From: [REDACTED]
Sent: 27 August 2013 20:54
To: Damian Sullivan
Cc: [REDACTED]
Subject: Re: R/152/13 8 West Mead, East Preston

Further to our conversation last Friday, just a reminder about confirming the deletion of the front boundary wall at the above address and amended plan of drawing number 15/13/06 dated May 2013 at your first convenience.

PROJECT Proposed front and rear extensions including extension to garage with pitched roof and new raised front wall at 8 West Mead, East Preston. BN16 2SL	Scales 1:50, 1:100 1:500, 1:1250	Revisions	
	Date May 2013		
	Drawn srb	Drawing No 15/13/06	3
CLIENT Mr & Mrs K Drew

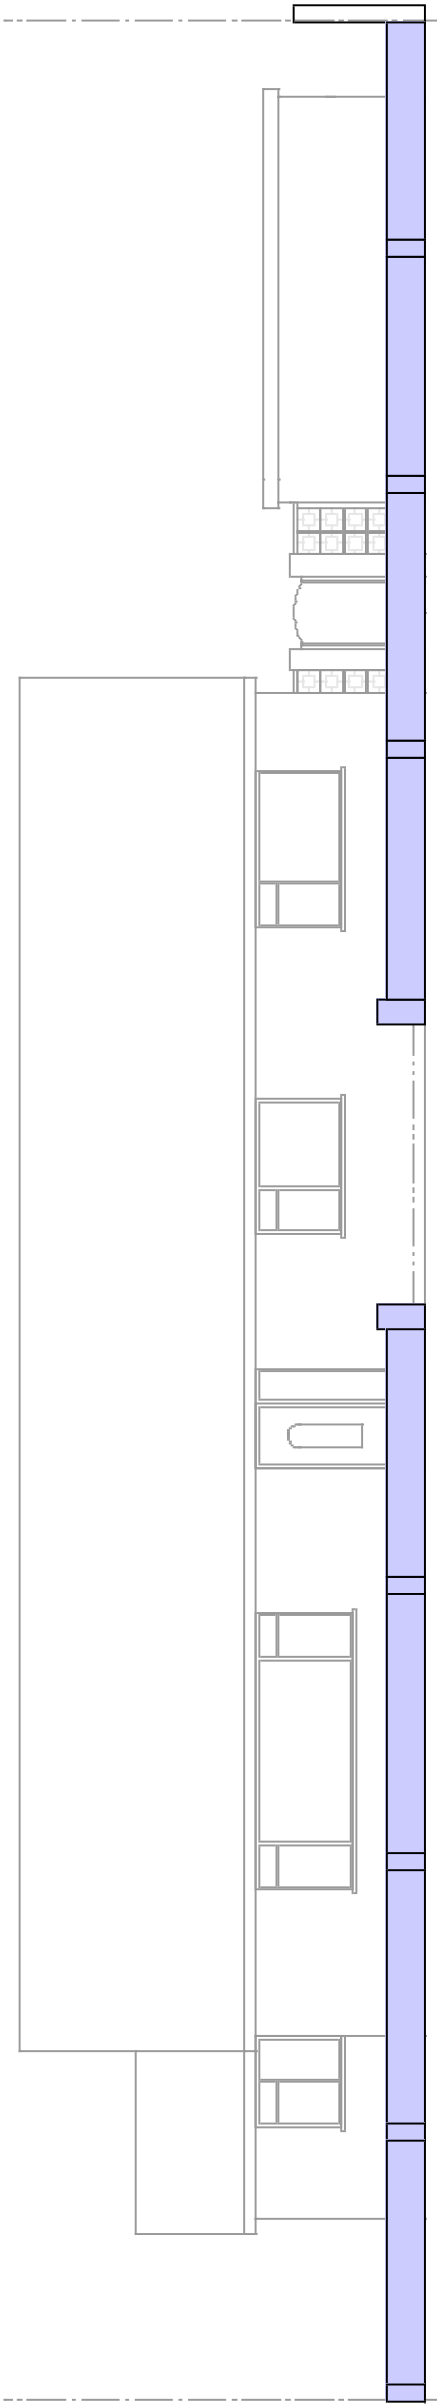
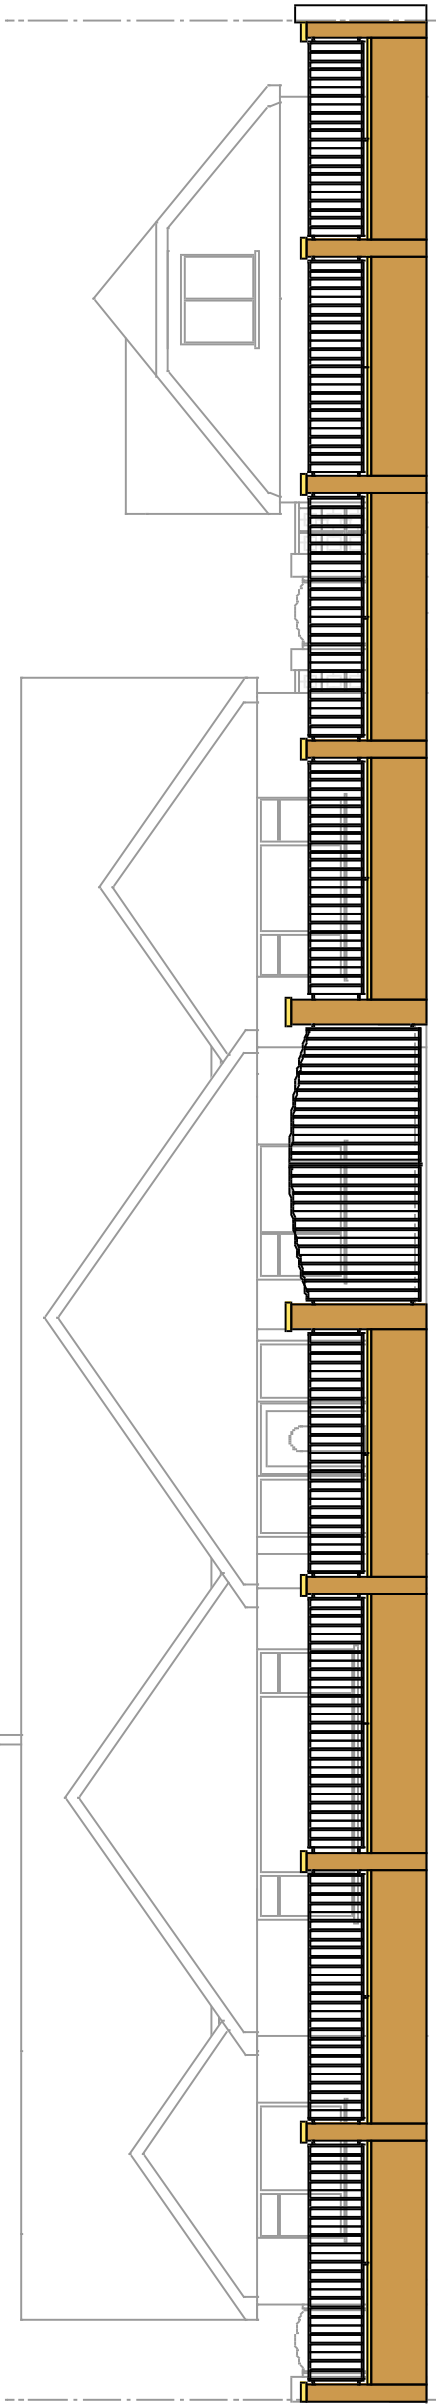
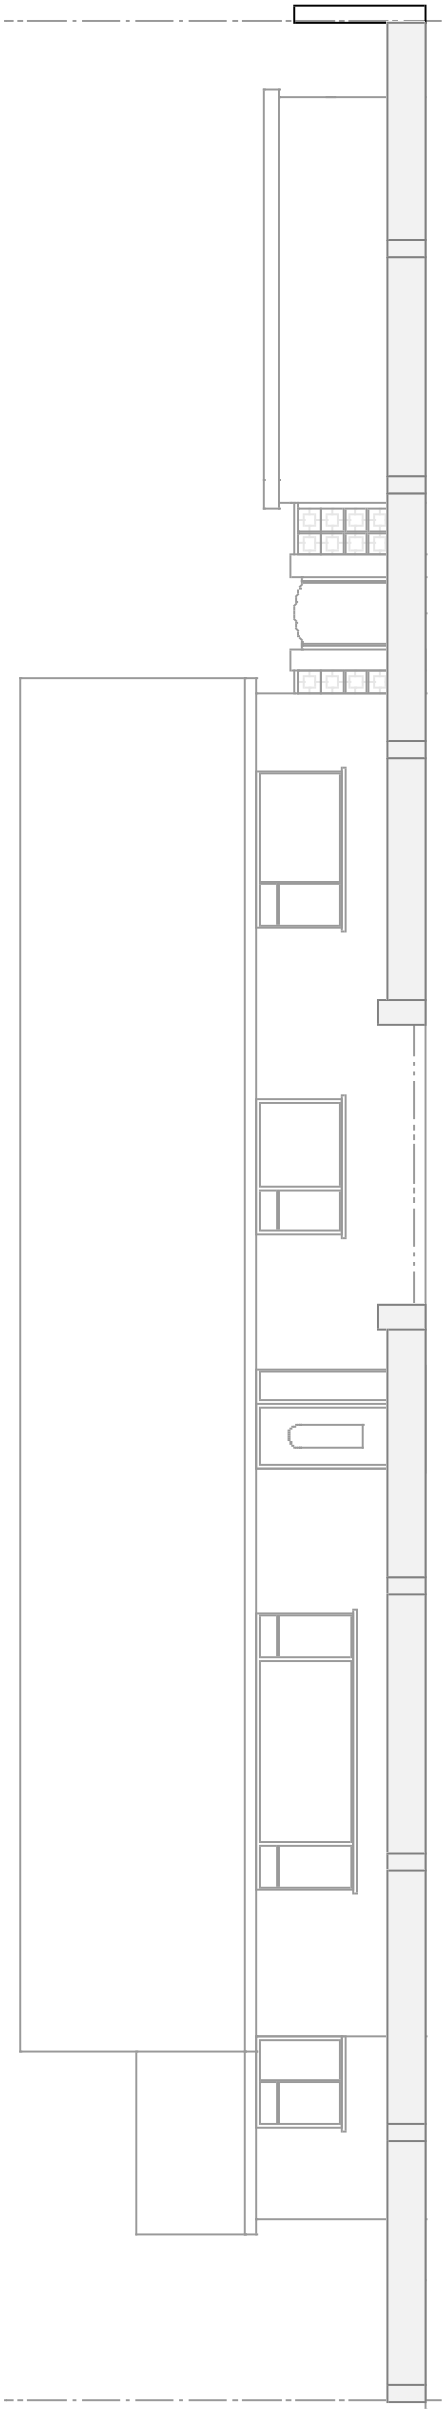
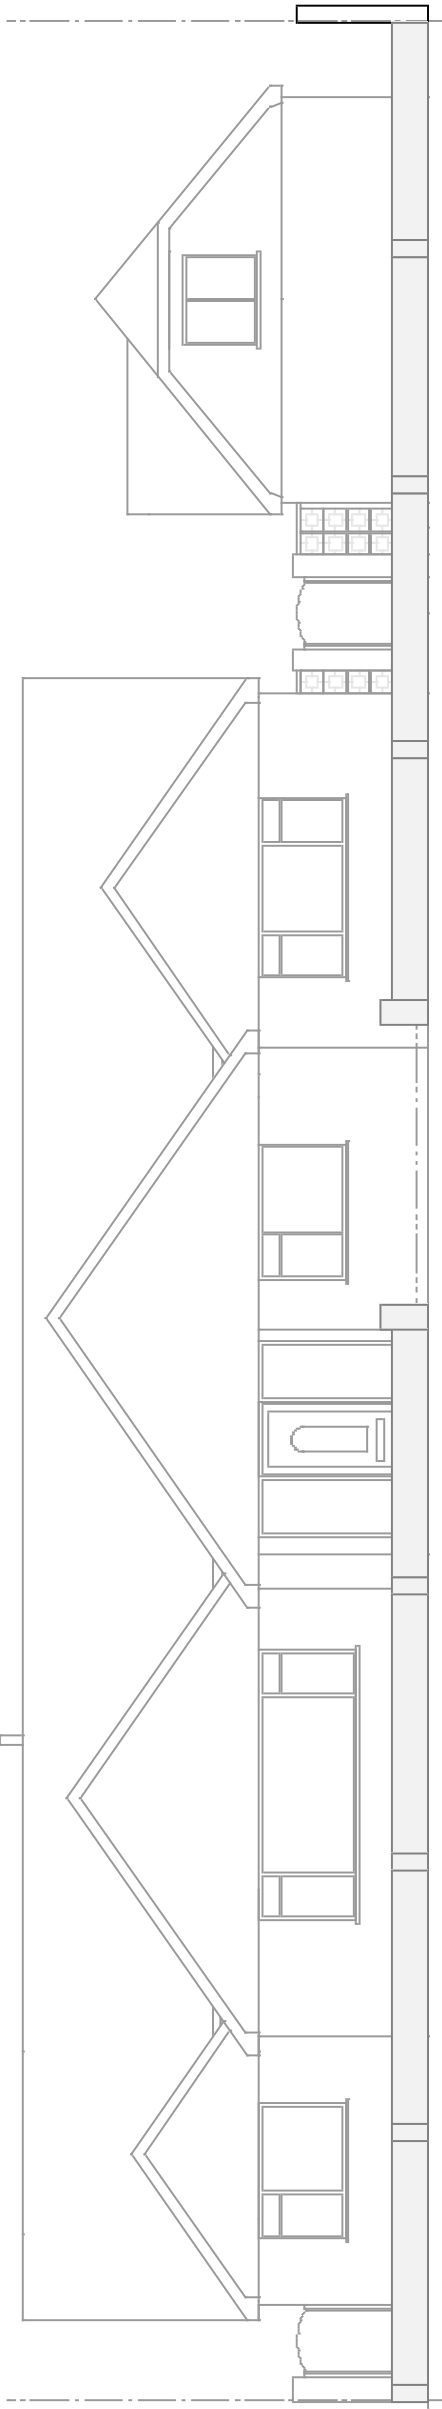
Obviously my client would like to negotiate some kind of front boundary screening at some time but given that this may have a bearing on the existing proposal I agree to withdrawing this element of the plans which is shown on drawing no 15/13/06 - 03 and leave only the extensions to the dwelling and the garage.
